OBSERVATION/SUBMISSION TO PLANNING APPLICATION

Case Reference: 324113

Re: Observation to the proposed development of open-cycle gas turbine (OCGT) and generator with ancillary equipment.

Location: Pollnagroagh and Rathmorrissy (Townlands), Athenry, Co. Galway

Purpose		PLANNING			
Title		SITE ACCESS SIGHTLINES			
Original Scale	Design/Drawn	Checked	Authorised		
SHOWN at A1	PS	ND	AJB		
Date	Date	Date	Date		
01.12.25	01.12.25	01.12.25	01.12.25		
Status	Drawing Number	Rev			
A2	PEK3-ATK-ZZ-01-DR-CE-901200	0

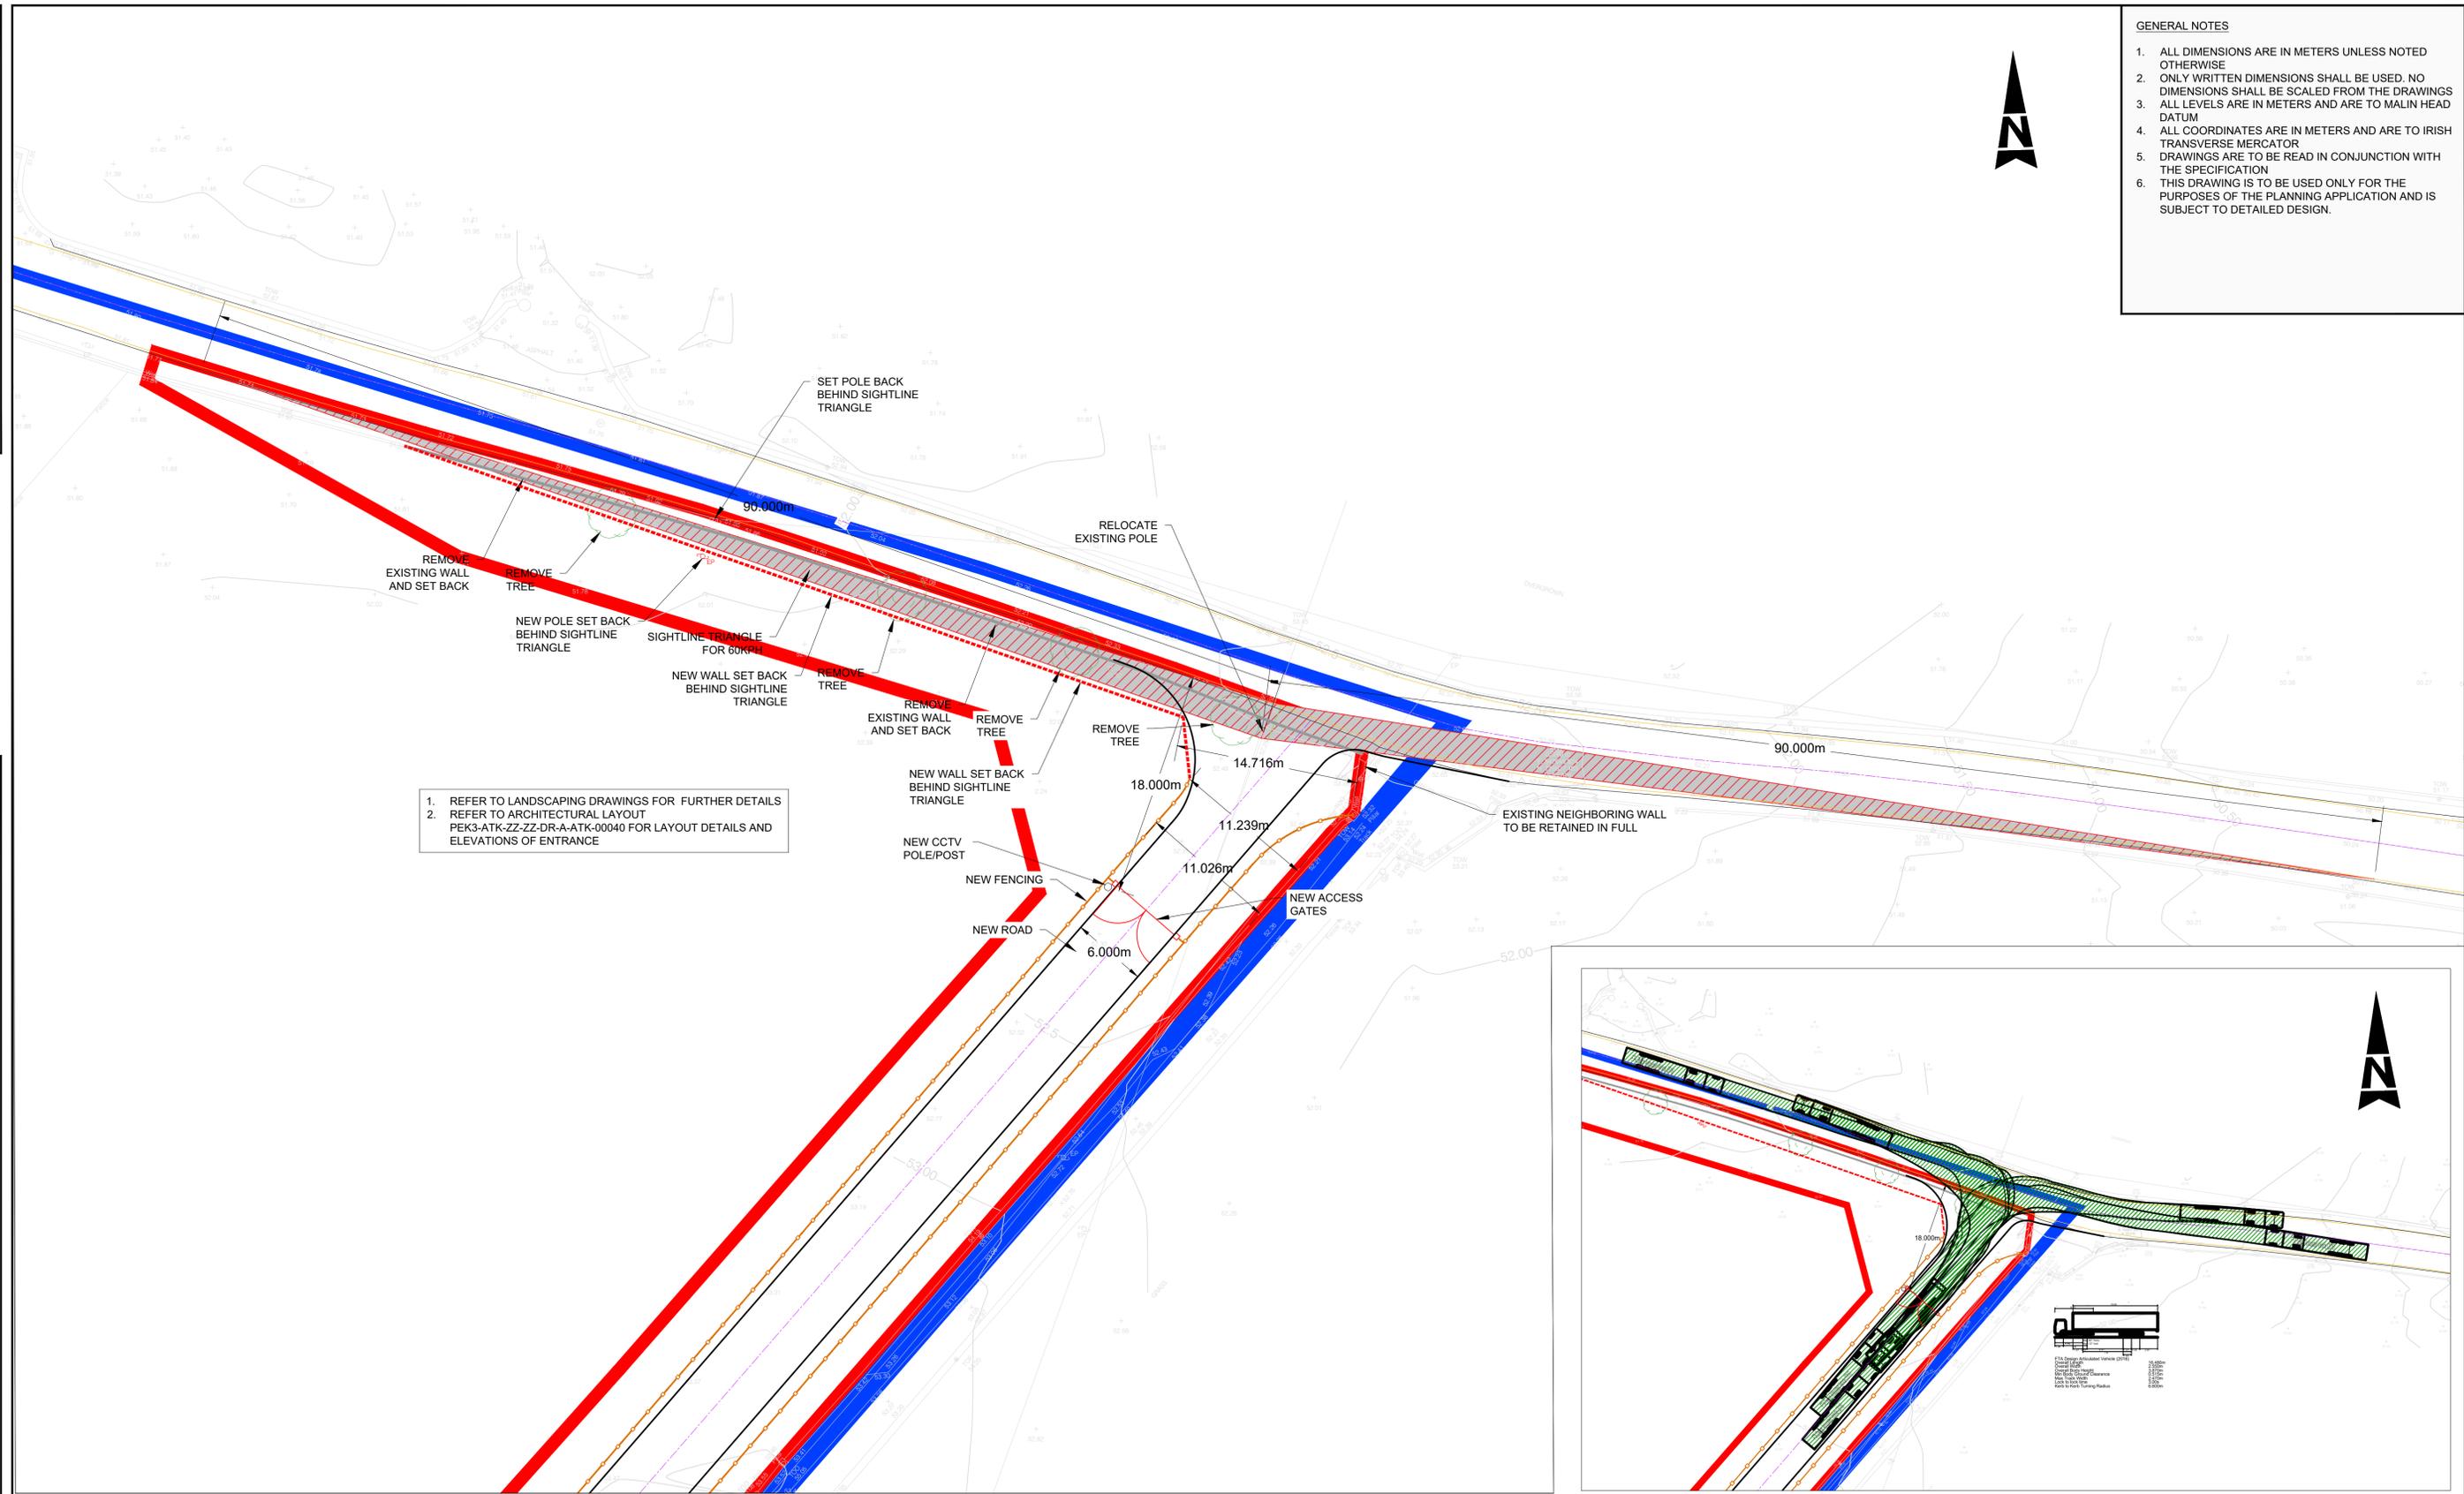
The placement of a site entrance at this hazardous location on the L3103 introduces significant and clearly identifiable safety risks, including restricted road width, lack of a hard shoulder, and severely limited visibility due to blind dips and corners. Despite these known constraints, the Environmental Impact Assessment does not adequately assess the safety implications of this access point.
